Indaver Rivenhall IWMF DCO

ENVIRONMENTAL STATEMENT [PINS Ref: EN0101038]

ES APPENDIX 5.3: SCHEDULE OF SCOPING OPINION COMMENTS AND RESPONSES

Document Reference: EN0101038/APP/6.2

Figure 8.1: Sensitive Receptor Locations identified in Condition 38

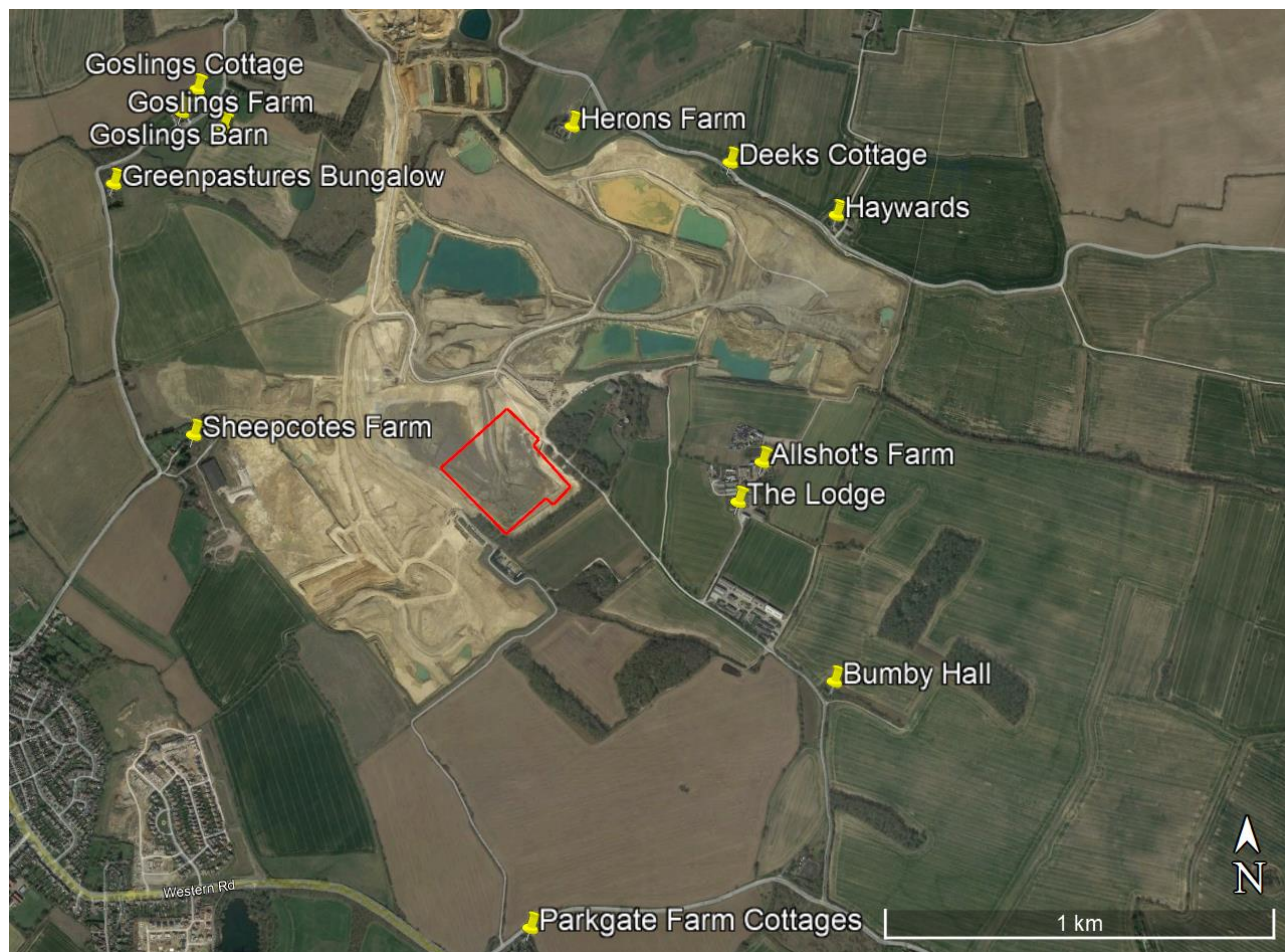
Identification of noise effects on ecological receptors	<p>The study area for the noise assessment, as stated in paragraph 8.3.2, includes the closest noise sensitive off-site receptors.</p> <p>Paragraph 2.1.15 of the scoping report states that the closest ecological designated sites are Storey's Wood Local Wildlife Site (LWS) and Upney Wood LWS approximately 290m south and 900m south east of the Site respectively. It is noted however, that these ecological designations are not included within the</p>	Details of the noise sensitive receptors considered in the ES is provided in Chapter 8: Noise and Vibration (Doc Ref. 6.1) . Full justification is provided where potential sensitive receptors (including ecological receptors) are excluded from the assessment.

Topic	Summary of Comment	Action / Response
	<p>noise assessment and only properties have been identified as noise sensitive receptors in paragraphs 8.5.6 to 8.5.8.</p> <p>The ES should ensure that all noise receptors are identified, and if receptors are to be excluded from the assessment, a justification should be provided.</p>	
Increased volume of steam to turbine	<p>The scoping report states that although the total amount of steam generated by the Consented Scheme will be changed by the Proposed Development, Works No 1 or Works No 2 will allow “a greater volume of the steam generated by the boiler to be sent to the turbine allowing the turbine to run more efficiently.</p> <p>The scoping report does not state how this efficiency will be achieved. It is unclear if the increased volume of steam will increase the number of turbine rotations and whether this will lead to a change in noise or vibration effects. The ES should identify the impacts arising from the increased volume of team sent to the turbine as a result of the Proposed Development on relevant has on noise and vibration.</p>	<p>The generator is required to operate at a fixed speed in order to generate electricity at the correct frequency for the grid (50 Hz). The turbine is connected to the generator so runs at same speed. The effect of sending more steam into the turbine is that there is more energy available, which equates to greater mechanical power from the turbine and therefore greater electrical power from the generator. This would not lead to increased noise or vibration.</p>
